Report of the meeting of the Development Control Post-Committee Site
Inspection Panel held on 03-FEB-2015

REF NO: P/105/14/PL

LOCATION: Sefter Farm
Pagham
West Sussex

PROPOSAL: Demolition of agricultural store & extension to agricultural building

Proposed
Relocated Retaining Wall Details
September 2014
6807b-104
1:500, 1:20@A3

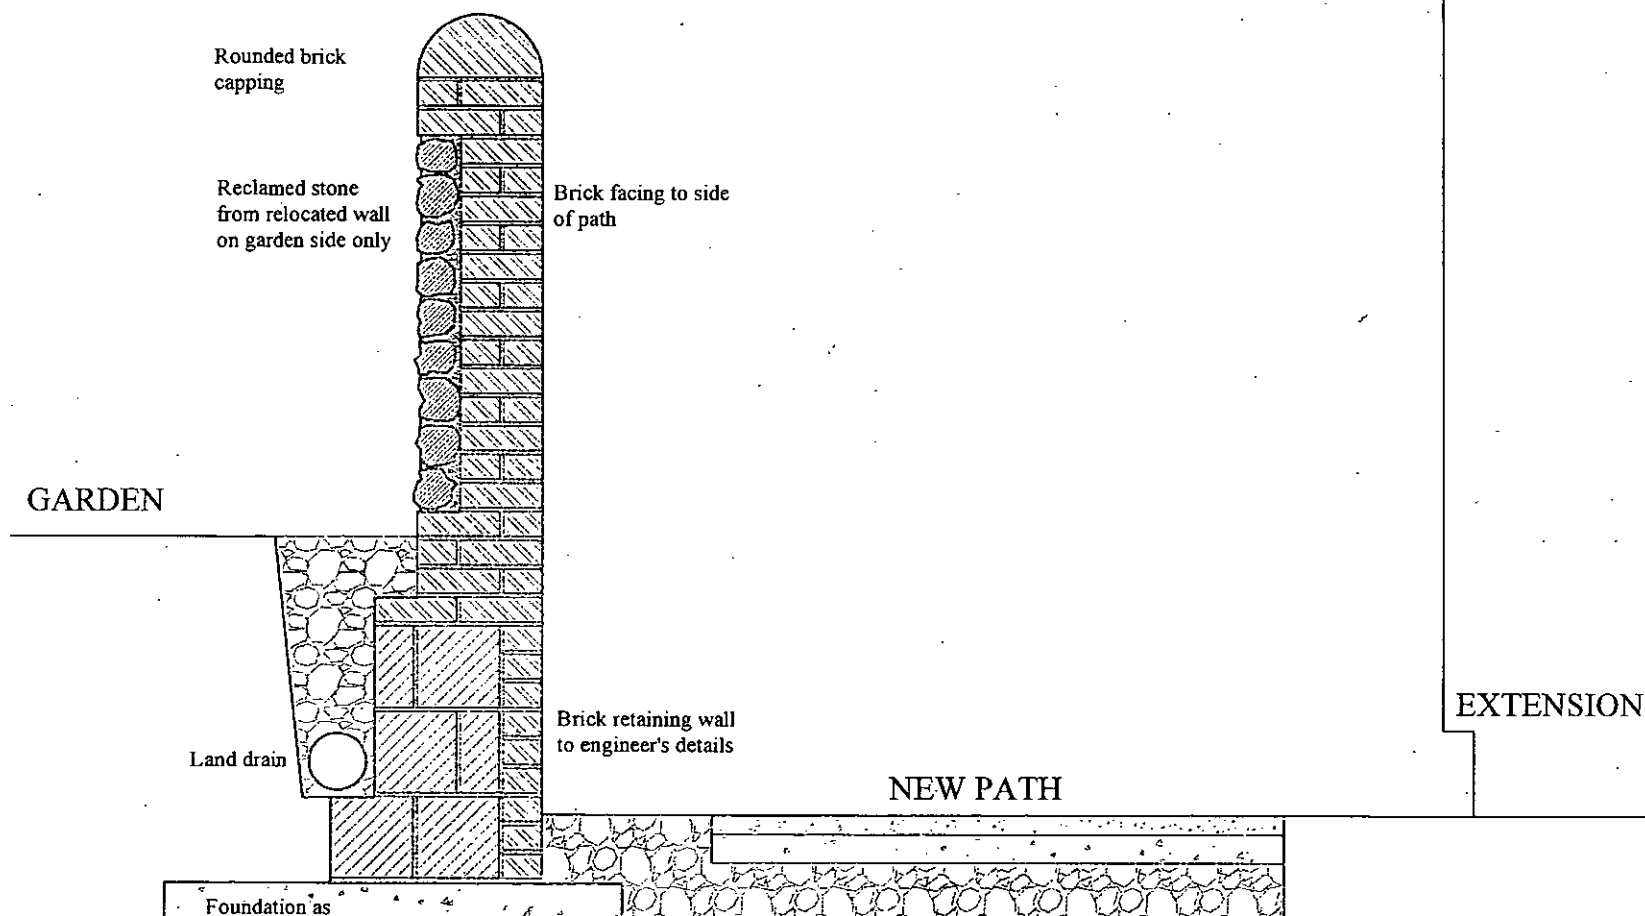
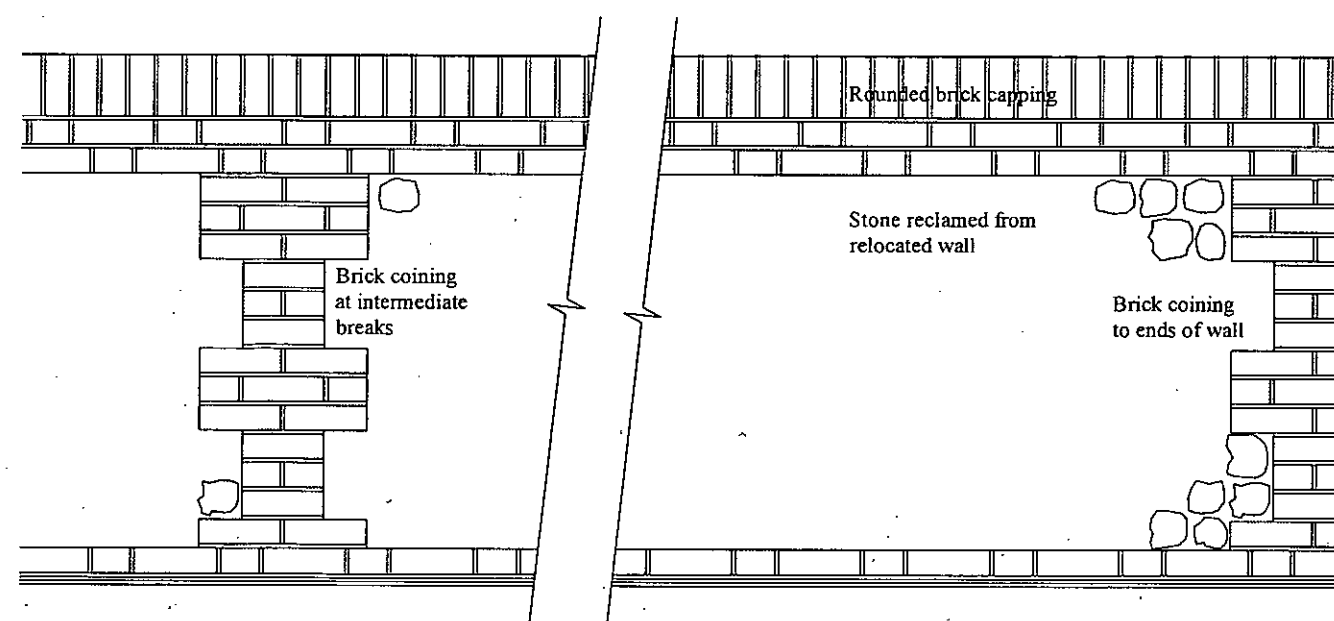
The applicant then submitted amended plans to show a change to the treatment of the existing bank to the east of the building (bank and fence rather than a retaining wall) and to confirm that material from the demolished wall will be used to repair other retained sections of the wall. However, the Councils Historic Buildings Adviser then made the following additional comments:

"Whilst we acknowledge that the material from the historic wall will be re-used, this rarely mitigates harm to the extent that would be required here. As the historic mapping shows, the new building will still encroach heavily into the old farm yard and the scale of it is likely to be significant within the setting of the listed building. To say this does not represent an element of harm (at whatever level) would be negligent on our part and would not meet the requirements of paras 129, 132 and 137 of the Framework. We did have a very useful meeting on site with the MD Mr Julian Marks and he did explain the reasons for the extension so we are aware of the justification. This however would have to be considered in the broader planning balance in terms of potential public benefit etc (para 134 of the Framework)."
